Messing and Inworth Action Group (MIAG)
and
Messing-cum-Inworth Parish Council (MCI PC) responses to
The Planning Inspectorate
Examining Authority (ExA)

**Various ‘Issue Specific Hearings’, 28th February and 1st March, 2023
in direct response to statements made by National Highways (NH)
experts.**

The overarching objective for both MCI PC and MIAG continues to be that the ExA, Planning Inspectorate and Secretary of State, recommend the adoption of **The Main Alternative** for Junction 24 of the A12/A120 Widening Scheme.

Drawing Title ENVIRONMENTAL STATEMENT NOISE STUDY AREAS, NOISE IMPORTANT AREAS AND NOISE MONITORING LOCATIONS SHEET 1 OF 1						
Drawing Status S4 - SUITABLE FOR STAGE APPROVAL						
Scale @ A3		1:70000	DO NOT SCALE			
Jacobs No.		B36601D1	Rev P01			
Client No.		HE551497

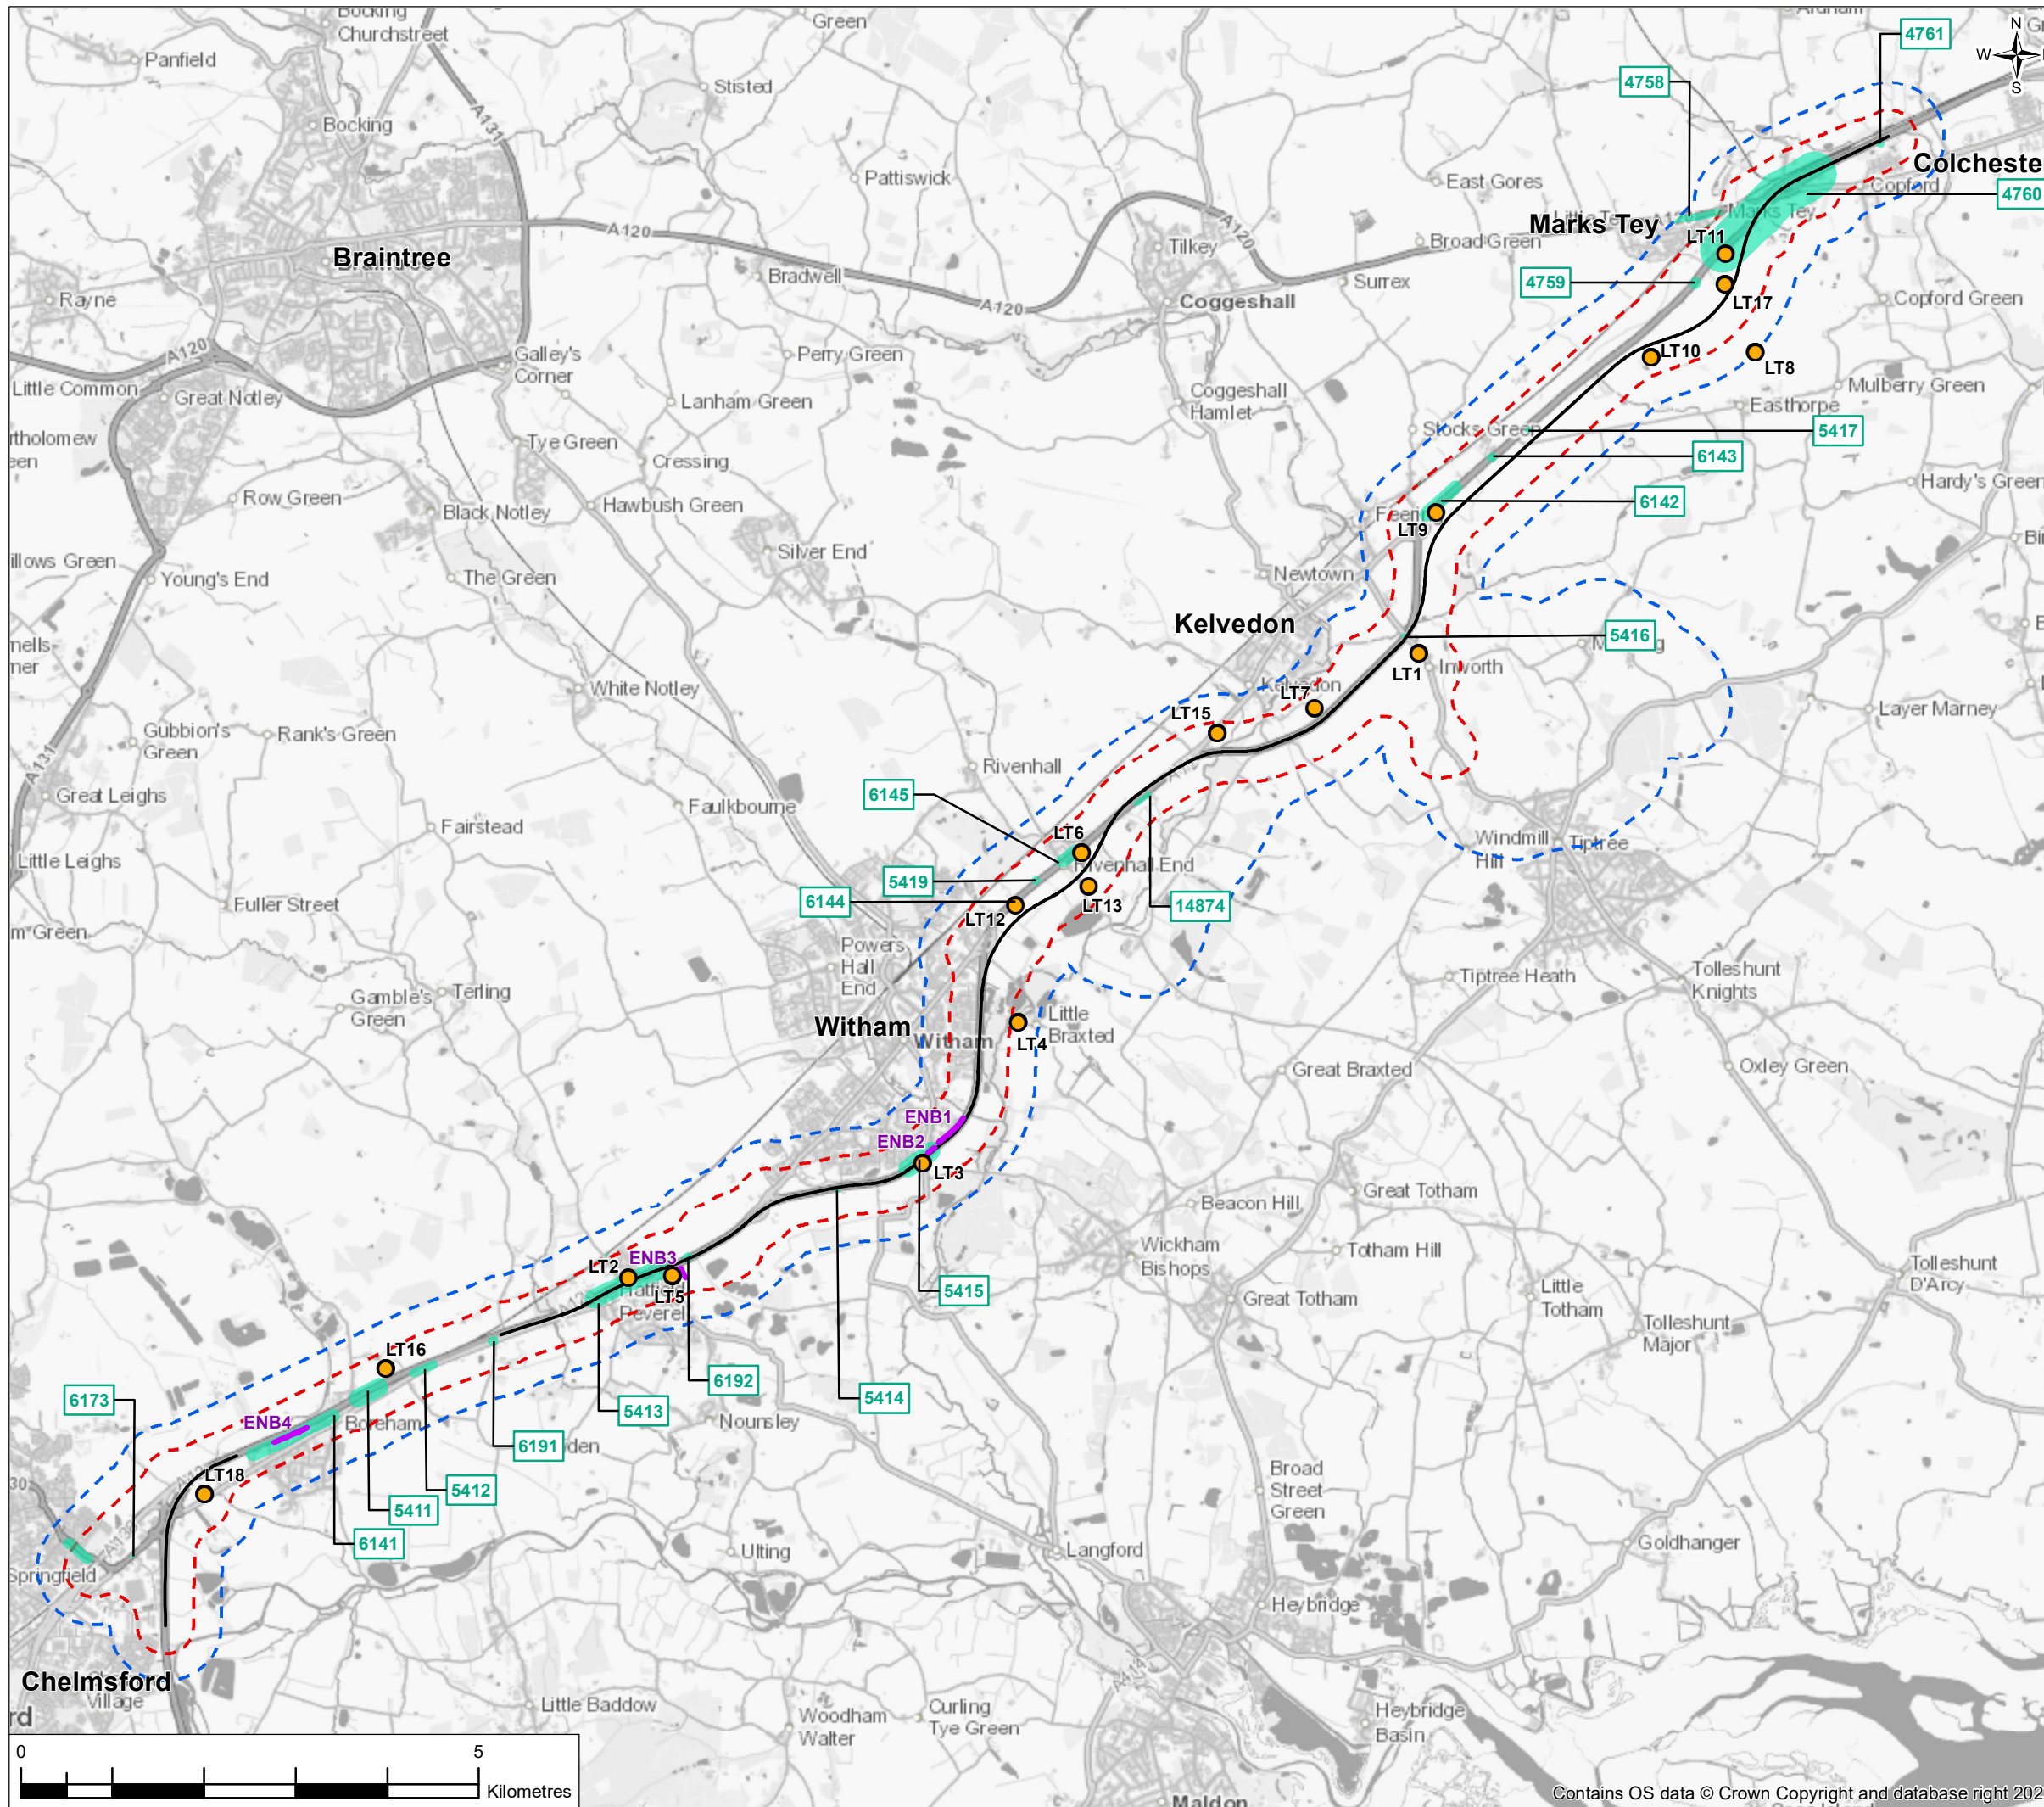
Noise and Vibration

12.7.1 Instructions on how to set the study area for an assessment of noise and vibration are provided within DMRB LA 111 (Highways England, 2020b). The distances used for the study areas have been informed by professional judgement and correspond to the distance where it is considered that receptors could potentially be affected by noise or vibration.

It is always concerning to read that something has “been informed by professional judgement” without any context being given to the exact nature, extent and level of judgement used. I question whether the operational assessment adequately complies with DMRB LA11, which addresses the area within 600m of new road links or road links physically changed or bypassed by the project or the area within 50m of other road links with potential to experience a short term change of more than 1.0dB(A) as a result of the project.

The above criteria bring in the roads through Messing for a more detailed assessment.
